Application No: 20/00634/DISC-2

Proposal: Discharge of Condition 15 (Car Park Management Plan) of 18/00513/REM-Village Centre North

Location: Heyford Park, Camp Road, Upper Heyford.

Transport Development Control

Graph 3-1 Summary of Weekday Parking Accumulations

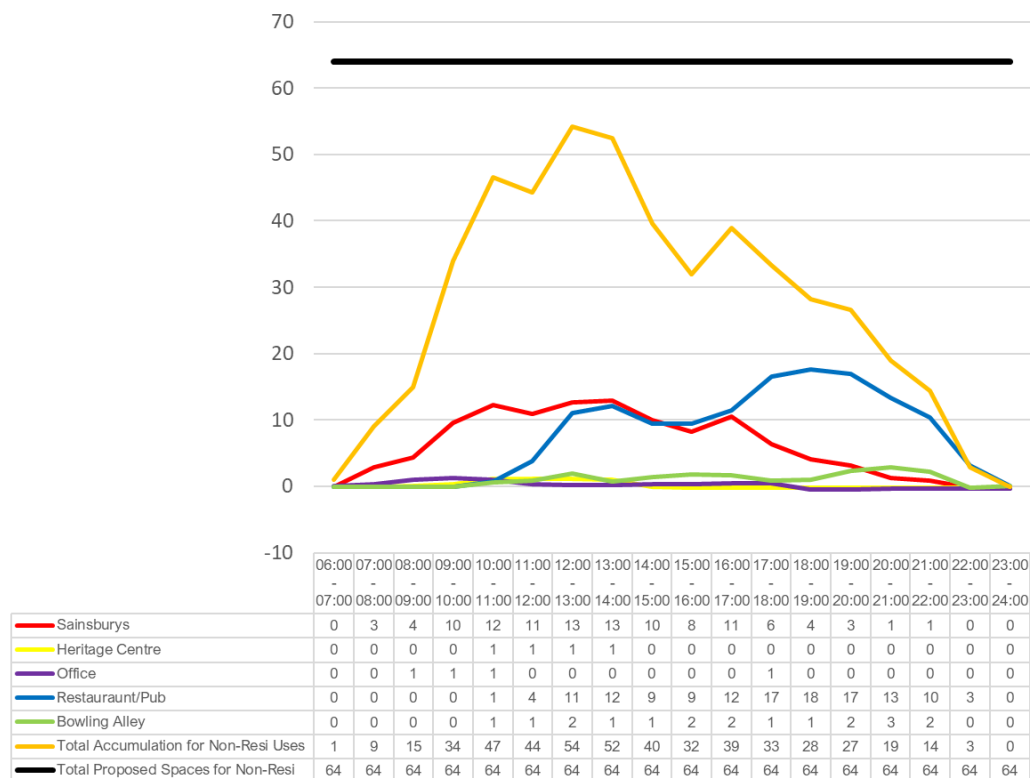
- Section 3.7 presents a total parking provision of 126 car parking spaces. This determined by allocations according to standards for various uses together with a parking accumulation analysis. An additional 12 car parking spaces are proposed over and above the maximum weekday accumulation determined. This is not considered sufficient to provide for occasions when the accumulated demand for non-residential uses will be exceeded. **Reason for objection.**

Figure 3-3 - Car Parking Allocation

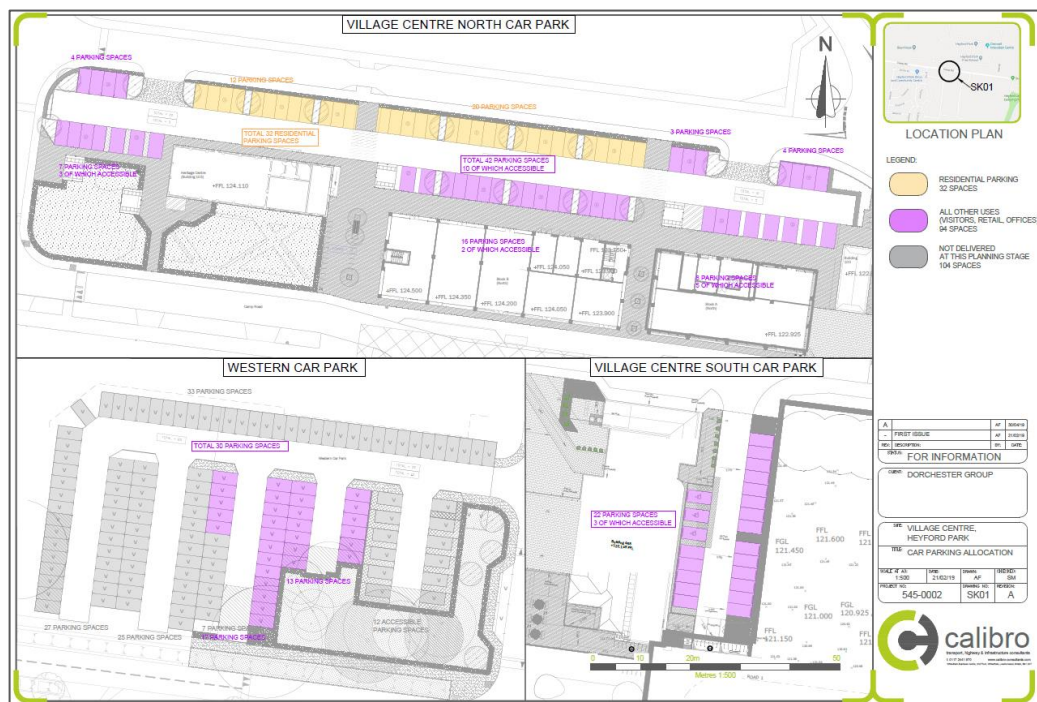
- Paragraph 3.5.3 states that visitor parking spaces “...*will not be specifically allocated...*”. This is not an acceptable approach. The County requires that visitor parking spaces are specifically allocated. **Reason for objection.**
